**Re: Event Center at 1611 Airtech Ct. SE
Erosion and Sediment Control Plan
Engineer's Stamp Date: missing (N15E017)**

Based on the information in your submittal received on 8/12/24, the above-referenced ESC Plan can't be approved until the following comments are addressed.

Landscape Plan

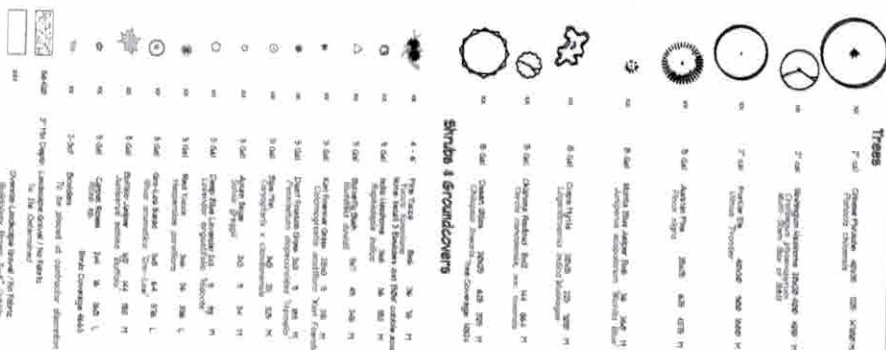
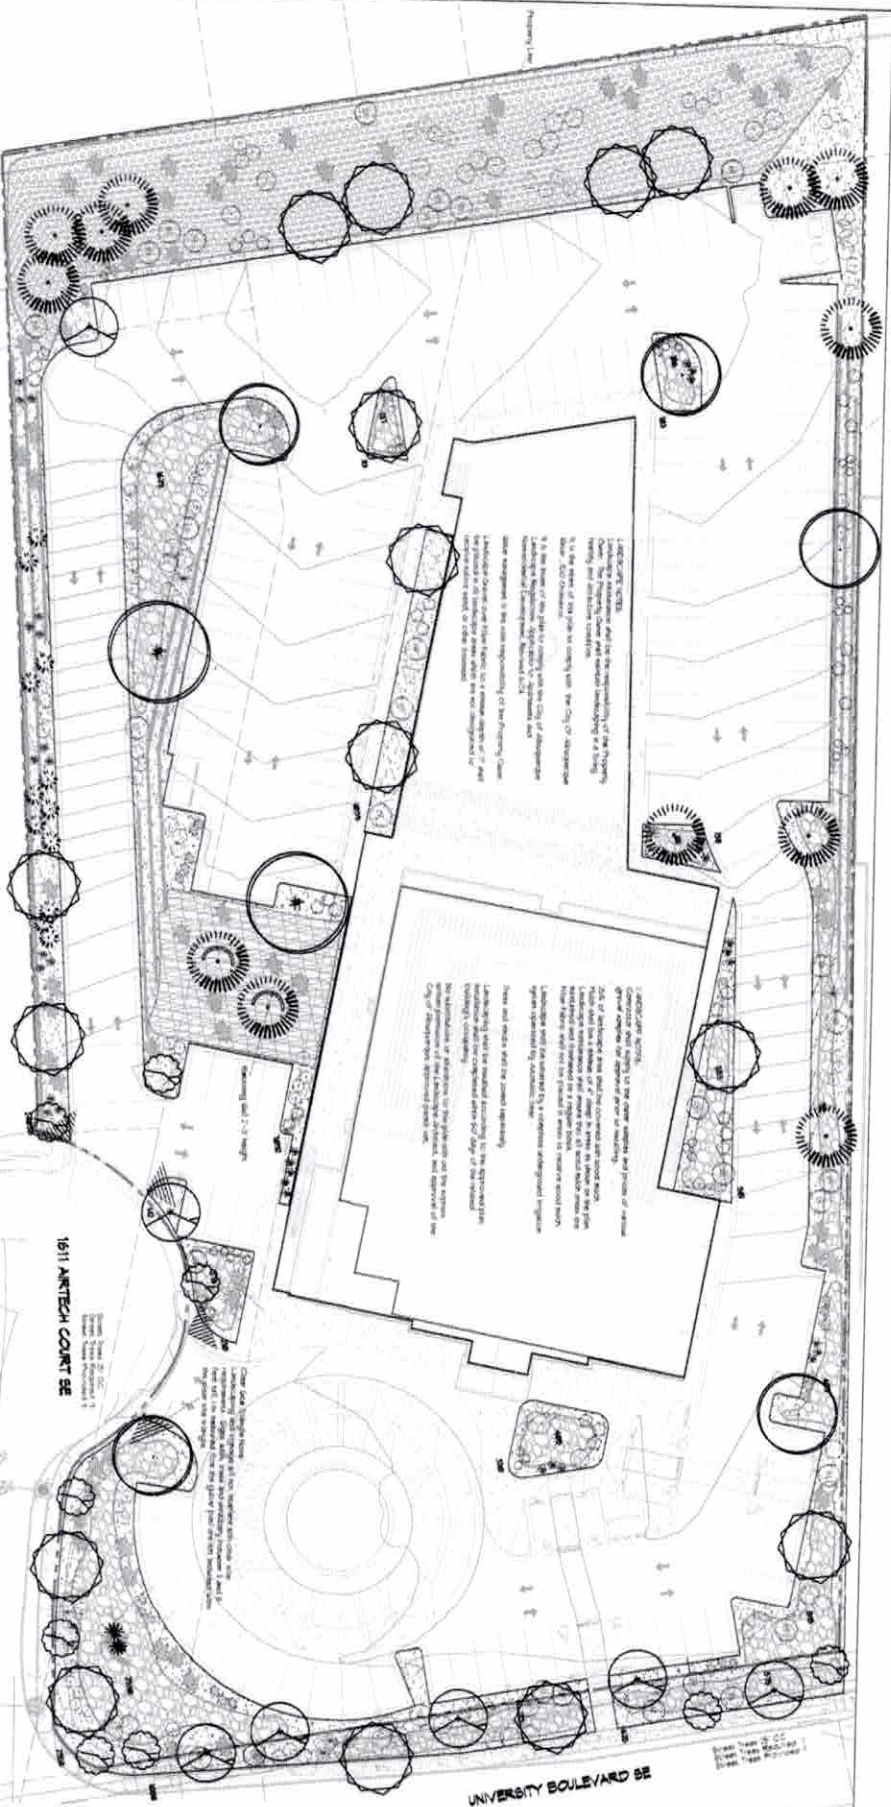
1. The ESC Plan can't be approved until after Hydrology approves the G&D Plan for each specific purpose, Site Plan, Grading, Building Permit, and Work Order. Hydrology has only approved the G&D Plan for the purpose of rough grading so far. The existing and proposed grades must be shown on the ESC Plan and agree with the Grading Plan approved by Hydrology per CGP7.2.4.b.ii. for Building Permit and Work Order prior to SWQ approval of the ESC Plan for those two purposes.

3. If any portion of the adjacent vacant lots is used for construction support activities, those areas must be included in the limits of disturbance on the ESC Plan, the neighbor's NOI is required, and stabilization must be specified on the ESC Plan for the disturbed portion of the neighboring lot. If not, please add a note to Stay Off the adjacent properties unless this information is added to the SWPPP and submitted to the City for approval.

6. The ESC Plan must include construction specifications for stabilization on the disturbed portion of Lot 6B-1 north of this site, per CGP 9.6.1.c.i.
7. The ESC Plan must include construction specifications for the stormwater controls, BMPs, including the silt fence, inlet protection (don't block the inlet), construction exit, and lined washout container per CGP 9.6.1.c.i. An additional sheet will probably be required for the details, so please number the sheets "1 of 2" and "2 of 2" so everyone knows how many sheets are in the plan set.

8. Show the location of the washout container on the ESC Plan.
9. The Date is missing from the engineer's stamp. Provide the engineer's signature and date adjacent to the seal/stamp per N.M. Code R. § 16.39.3.12. Update the signature & date on every sheet each time the plan changes.
